Figure 3.3: Phase 2

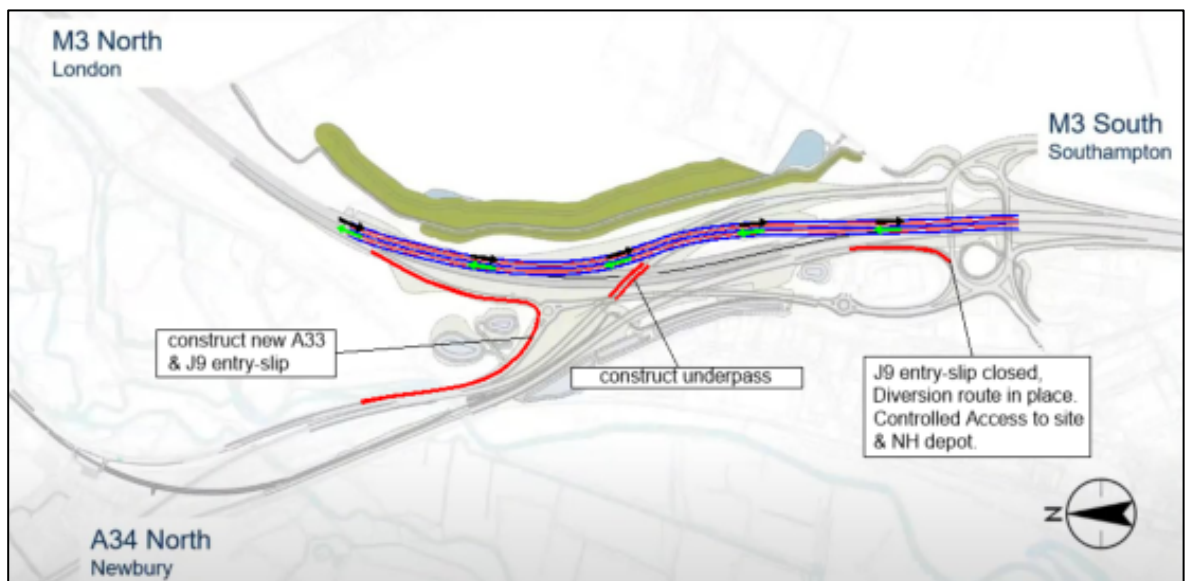
The Twyford Parish Council is very concerned about the diversion works proposed during phase 2 of the works. This relates to the increased use of the Hockley Cross Interchange (Junction 11) and its interface with the B3335 / A3090. National Highways have already acknowledged deficiencies in the operation of the traffic lights at this junction and the impact it has on pedestrians, cyclists and other users of the B3335.

Since a re-timing of the operation of traffic lights is required during the operation of the diversion route, along with a significant increase in volume of vehicles, the Parish Council is concerned that this will lead to a worsening of the impacts as a result of the deficiencies already identified.

In order to mitigate the effects of the J9 works, improvements to the operation of the traffic lights and road layout at the Hockley Cross Interchange (Junction 11) and its interface with the B3335 / A3090 must be carried out prior to the works commencing on the J9 improvements.
